Submission by Fen Ditton Parish Council ref ISH5

For 12 April 2024

This is FDPC’s submission at D7 with references to ISH5 – Traffic and Transport Agenda (EV-009a) and Action Points (EC-009b)

Submission by Fen Ditton Parish Council

M M
MOTT MACDONALD

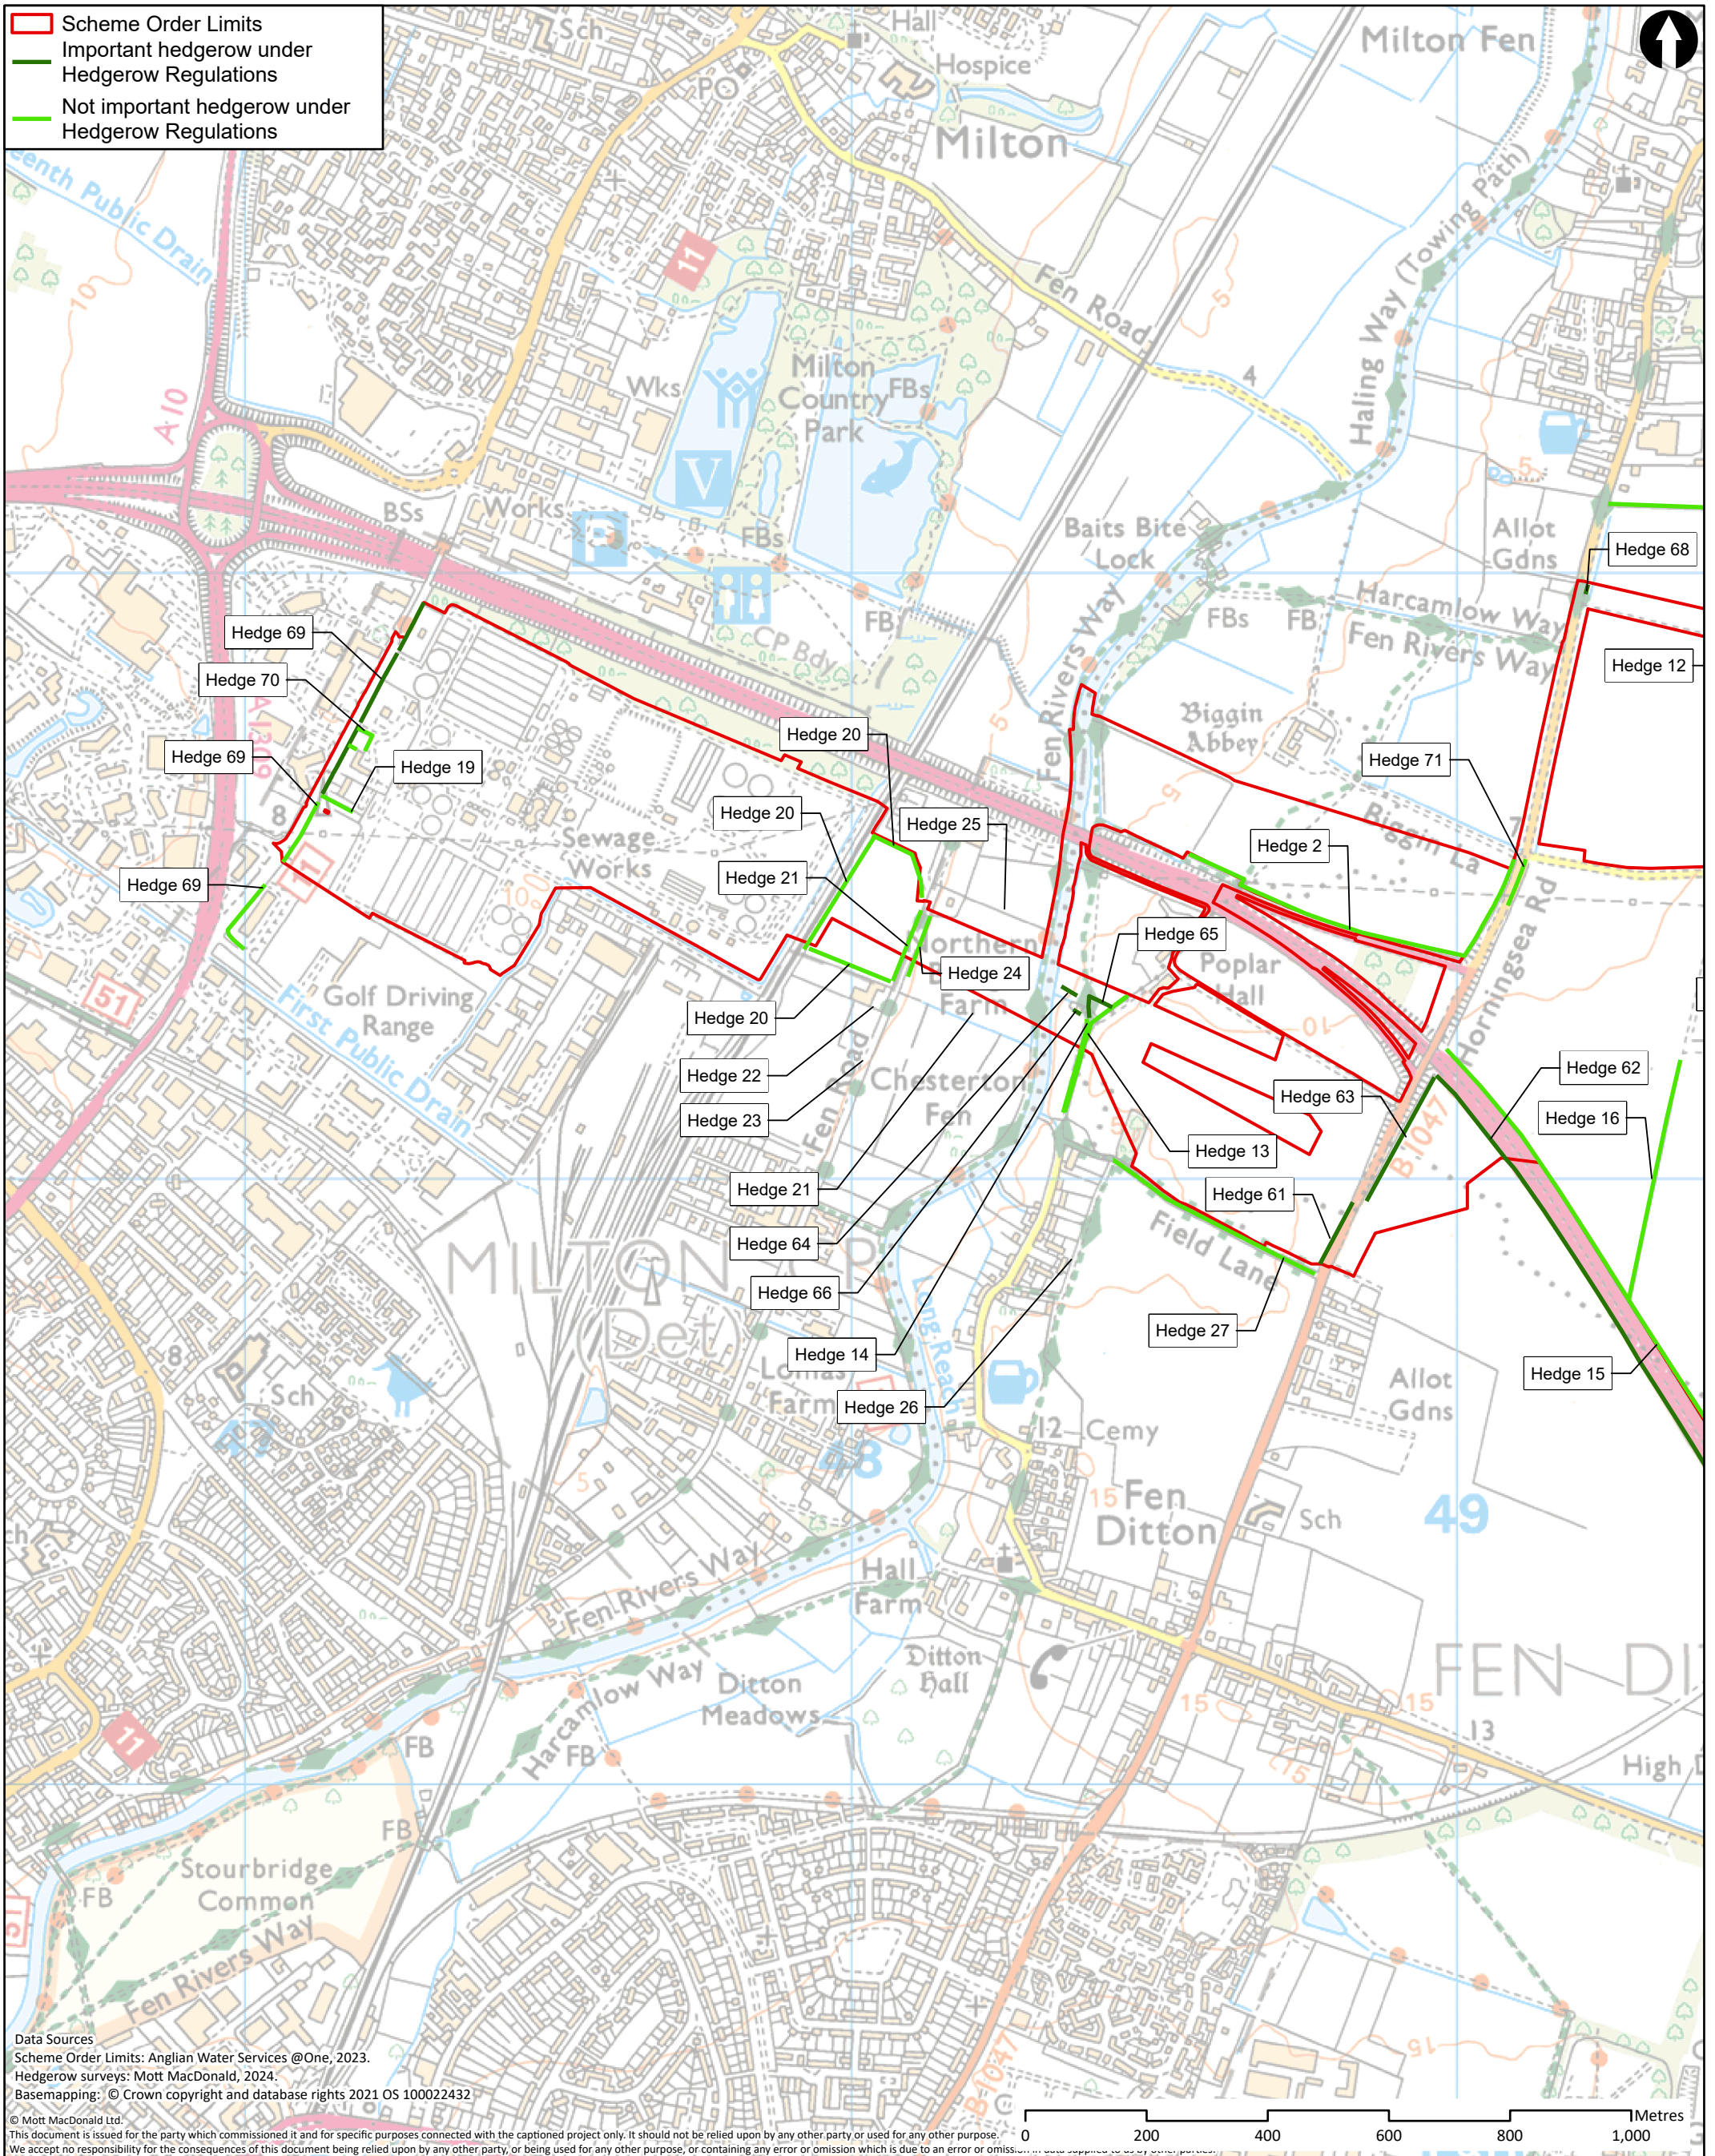
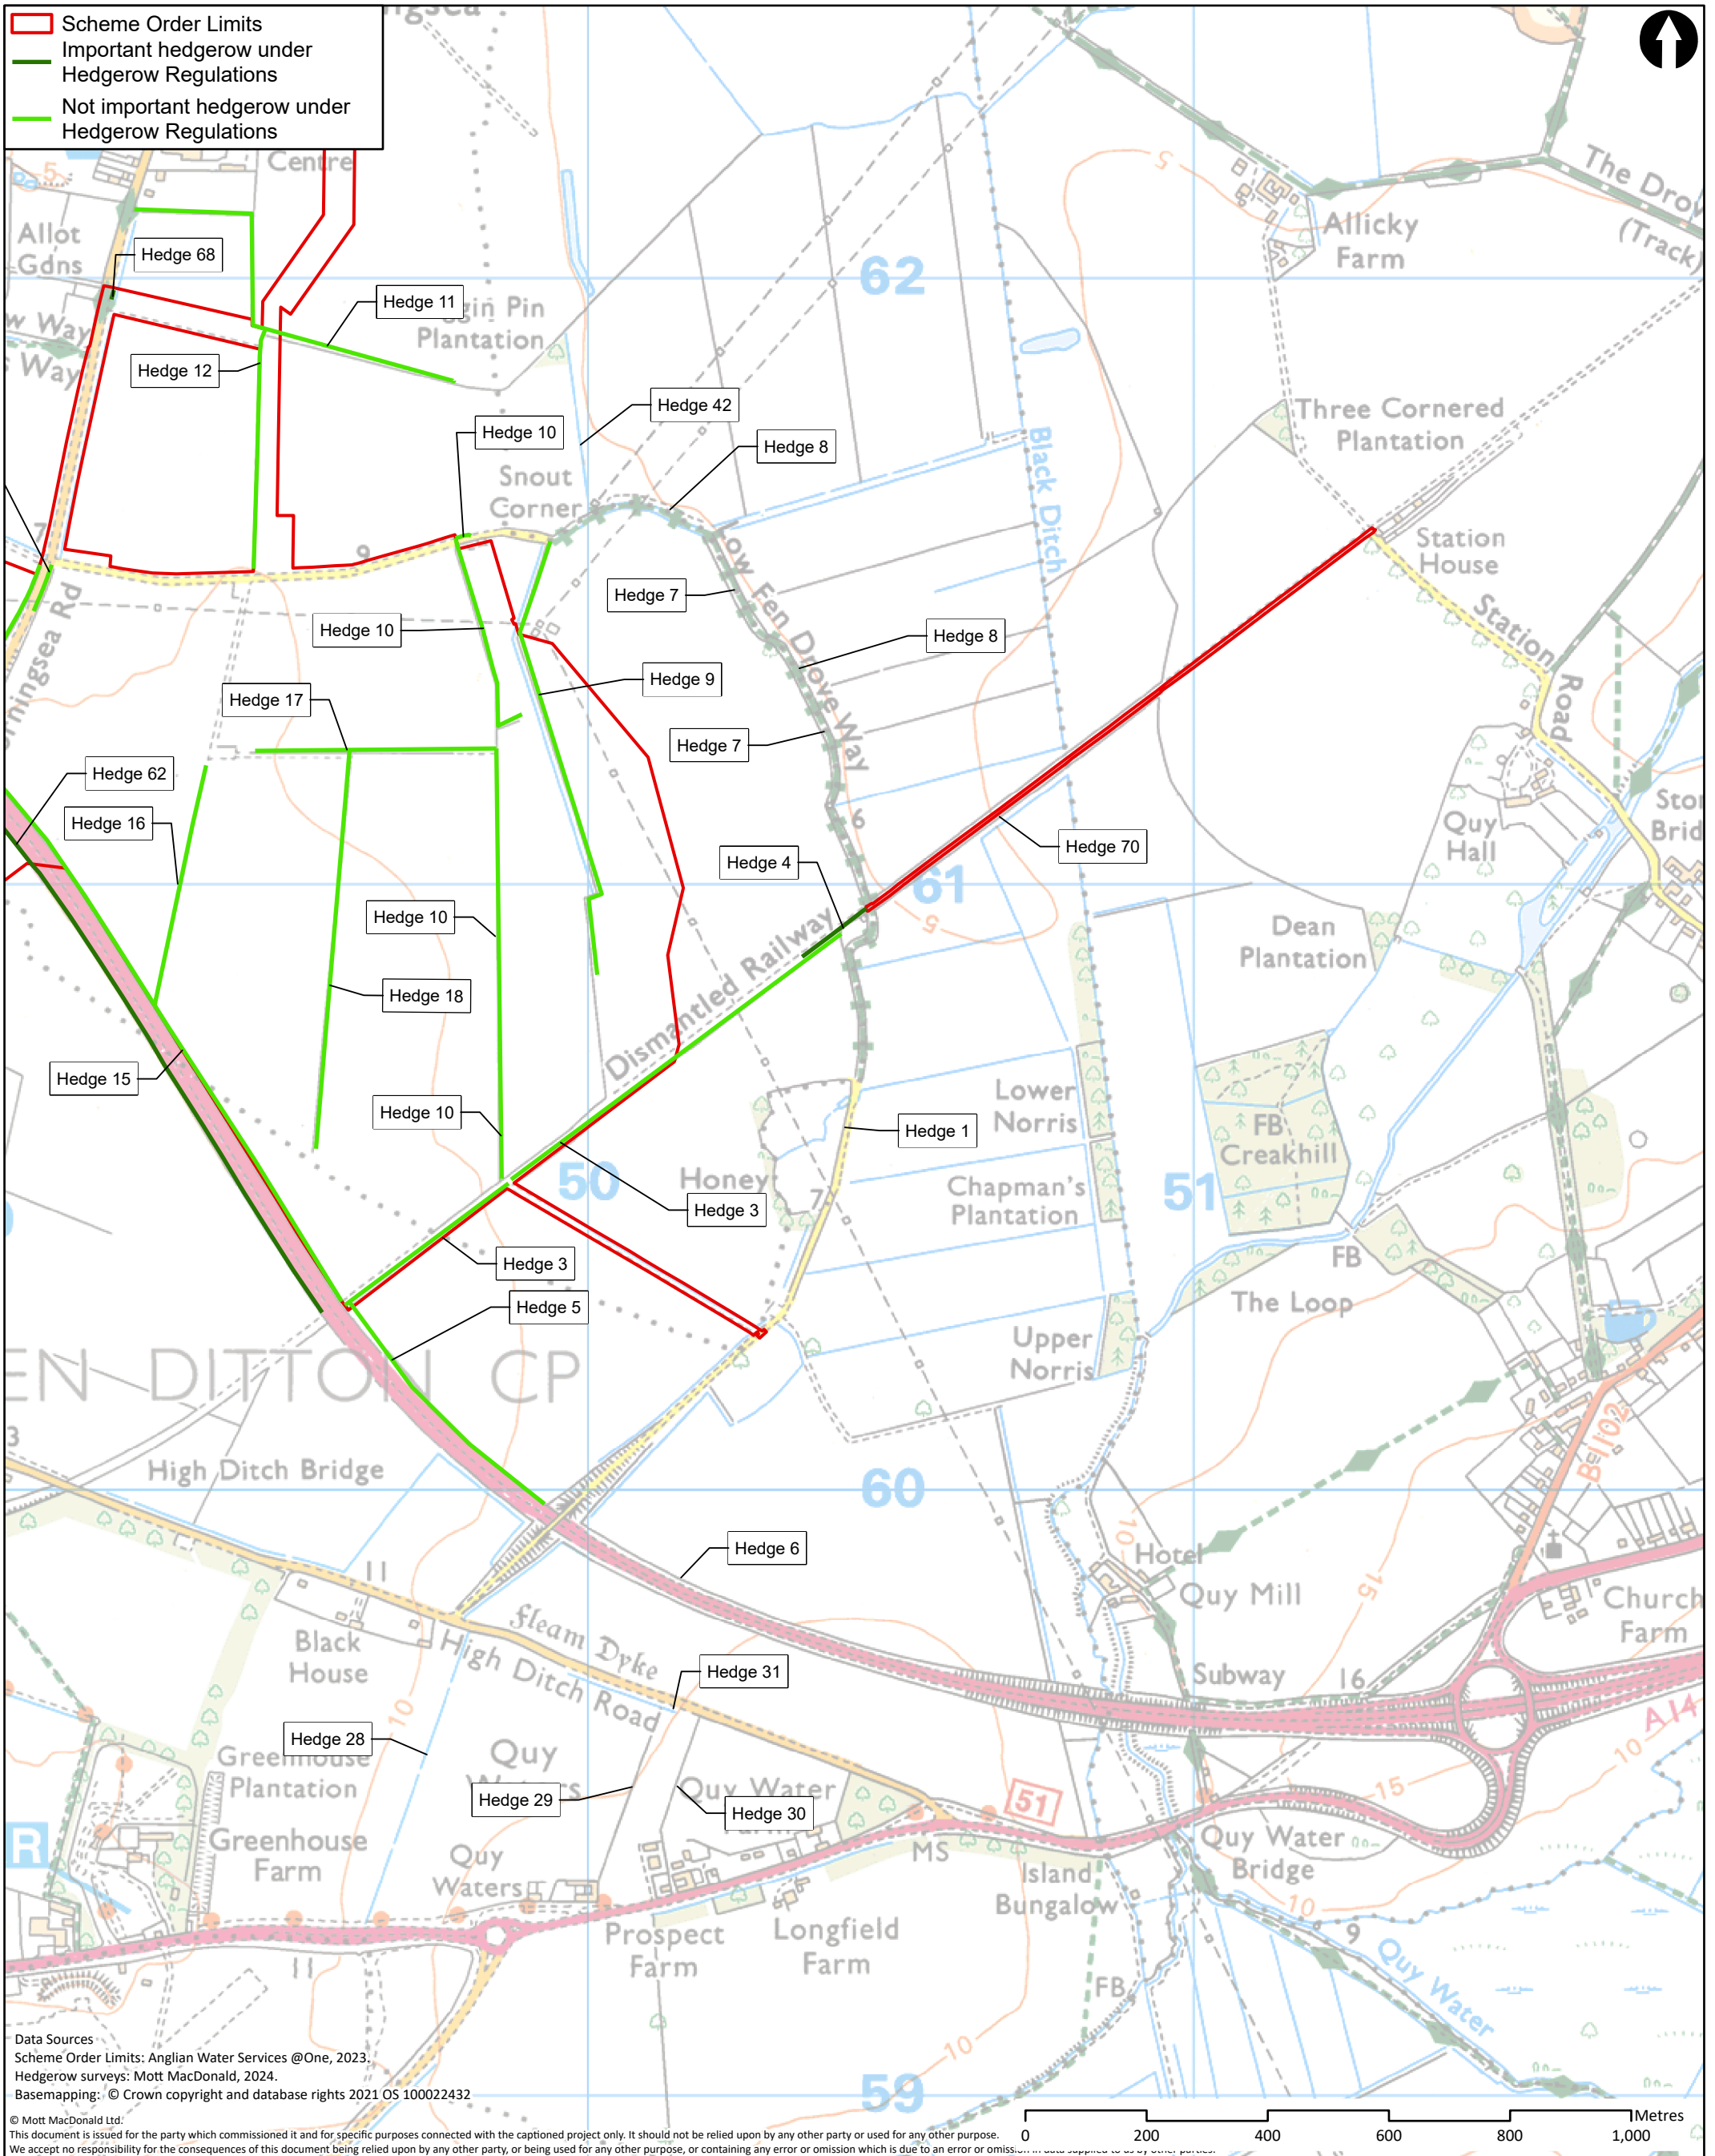
<p>Agenda Item 2 f) – Policy 23</p>	<p>FDPC noted that ‘arrangements.. and/or signage’ are covered in the County Local Plan Policy 23 para 3.2.3. FDPC requested that in addition to the proposed geofencing, signage banning HGV access to the WWTW is placed at the entrance to High Ditch Road at the Newmarket Rd junction during construction and operation. In operation, signage banning entry by HGV exiting the WWTW should be placed on Horningsea Rd at the junction with the A14 on slip at the lights. This request links to para 4.3.20 of ES Chapter 19 Traffic and Transport. FDPC welcomes Action point 11.</p>	<p>Chapter 19 Traffic and Transport (REP6-037) EV-009b</p>
<p>Agenda Item 4-AOB Hedgerows</p>	<p>FDPC have inspected the revised DCO Hedgerow Plans (REP6-005) and welcomed the corrections made but noted there are still hedgerows in the Parish within the areas where land will be acquired or used (ie the Scheme Order Limits) that are not shown correctly. FDPC accepts confirmation from the Applicant that hedgerows wholly outside the Limits had been removed</p>	<p>Hedgerow Plans (REP6-005)</p>

<p>from the Plans and that hedgerows crossing from inside to outside were still shown in their entirety.</p> <p>FDPC queried if areas of hedgerow and vegetation that could be retained could be protected through a mechanism under the LERMP.</p> <p>Post Hearing Note: Examples of possibly incorrect Hedgerow Plans are the inconsistency on Hedgerow Plans Sheet 3 where the hedgerow on the north side of Filly Lane is omitted whereas the Book of Figures – Biodiversity Sheet 8.6 (REP6-046) shows the same hedgerow with a small extent inside the Limits. Another example occurs where the vegetation running along the east side of Horningsea Road will be removed between points H5 and H6 but there appears to be 20m or more length with a 5m maximum width (these dimensional criteria are referred to in para 1.4.8 in Appendix 8.2: Hedgerow Baseline Technical Appendix) north of point H6 that has been classed as scrub rather than as a length of hedgerow bounded by scrub to its north.</p> <p>In view of the lack of time now available to check or ground truth the Plans, FDPC query if the Ecological Clerk of Works or others can be tasked with supervising the setting out of fence lines and reptile barriers to avoid unnecessary damage to existing hedgerows, trees or scrub vegetation.</p>	<p>Book of Figures – Biodiversity Sheet 8.6 (REP6-046)</p> <p>Appendix 8.2: Hedgerow Baseline Technical Appendix (REP6-063)</p>
